Red Rock Acres

Traffic Impact Study

LSC #194970
PCD File No P2010

LSC RESPONSES TO EPC TIS Comments

Figure 7
Short-Term Total Conditions
 Red Rock Acres (LSC# 194970)

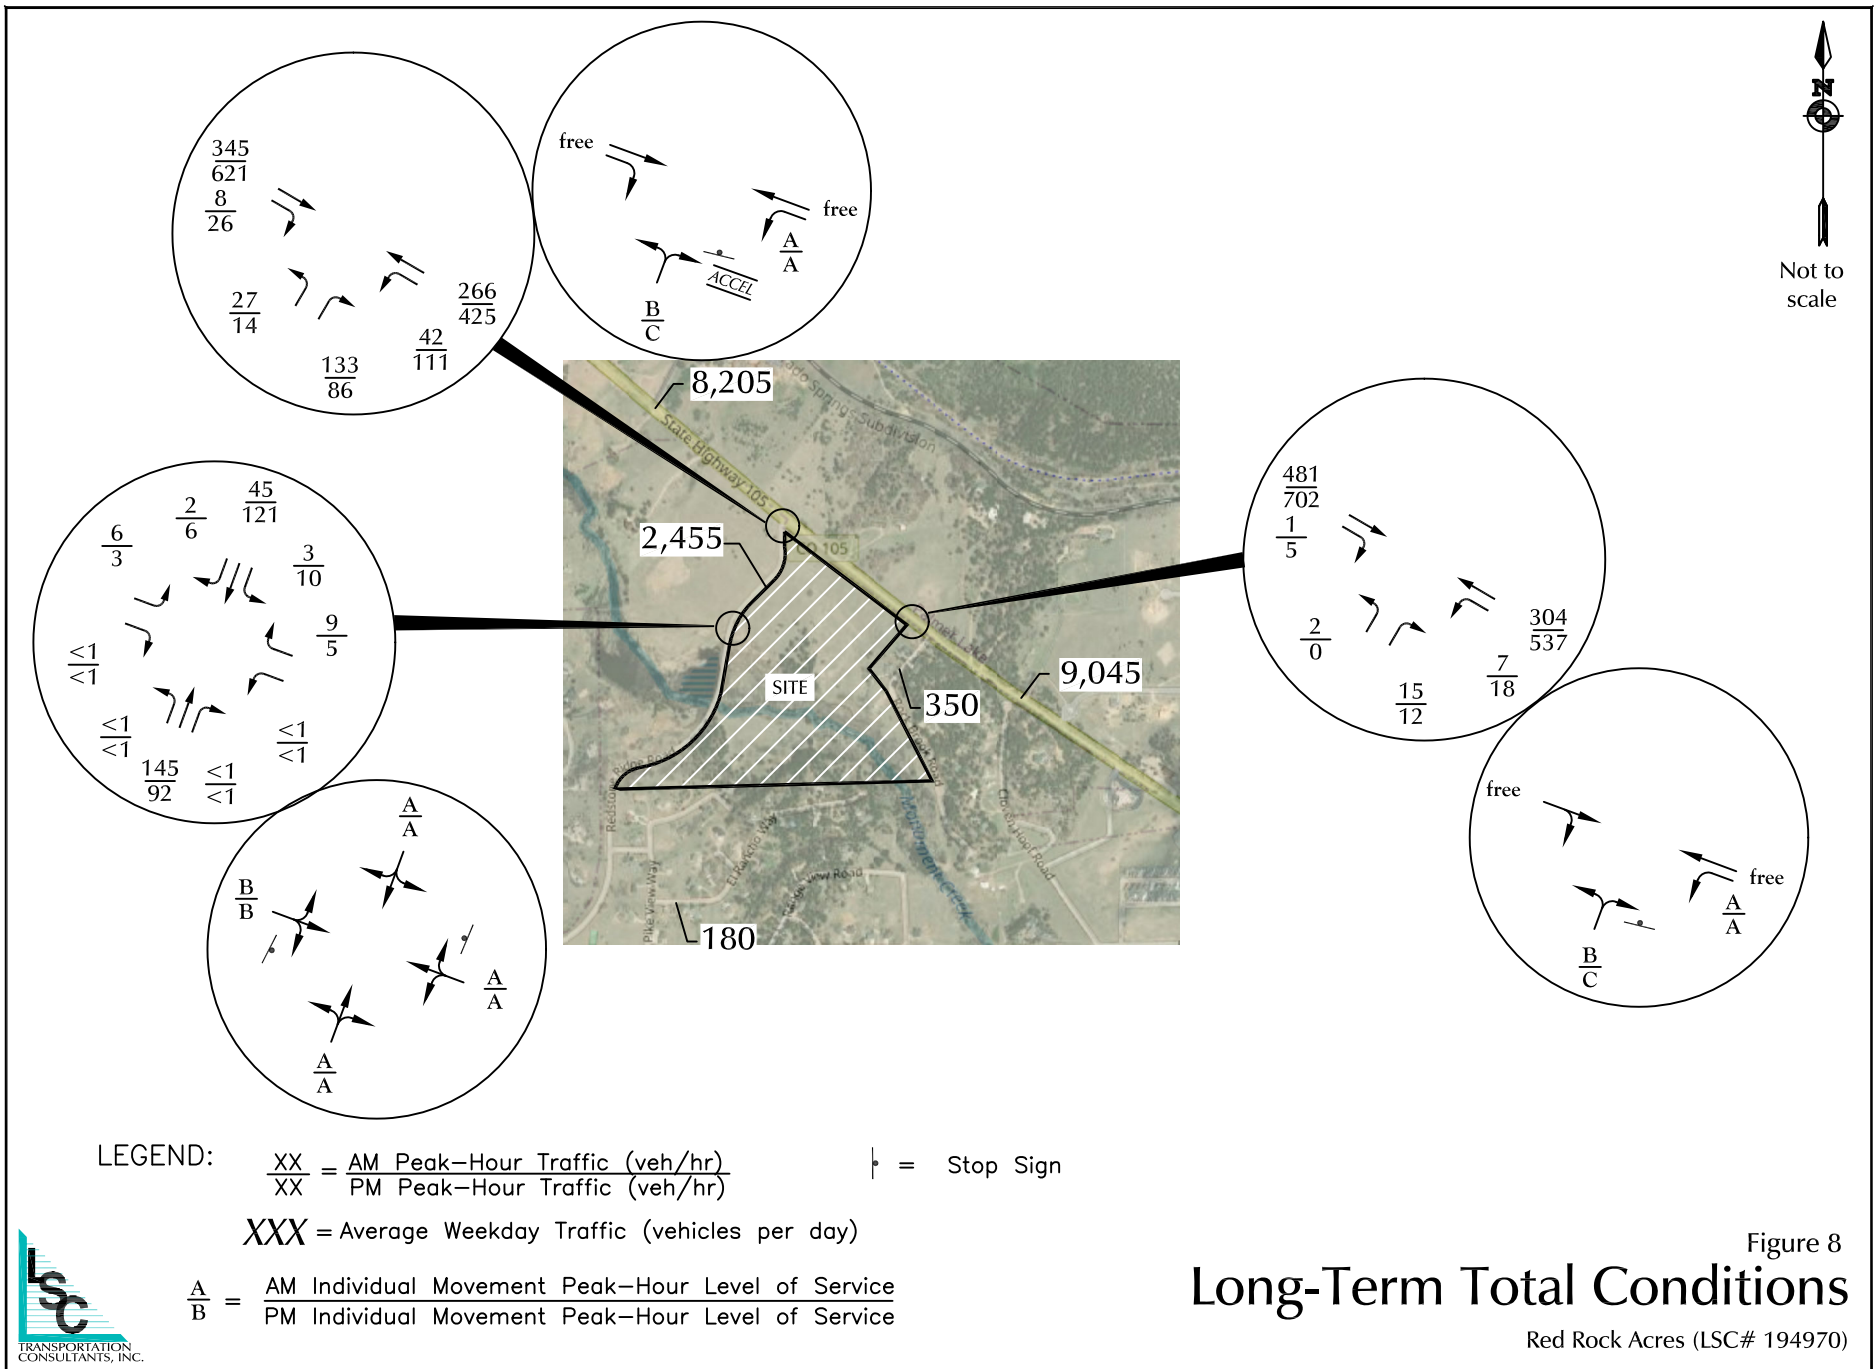
Per the VPH shown on these turn movements it appears that exclusive left and right turn lanes are required per criteria on Red Rock Ranch approaching hwy 105. Please address in your report and provided the lane characteristics.

LSC Response: LSC consulted with staff regarding this comment and the interpretation of the criteria and the application of turning volume thresholds in ECM Section 2.3.7.D. Staff confirmed their interpretation that the thresholds apply in this situation.

Therefore, LSC has updated the report to reflect separate northbound left and right lanes on Red Rock Ranch Road on the approach to Highway 105. The applicant would have the option to request a deviation, but the timing of a deviation request would be at Preliminary Plan.
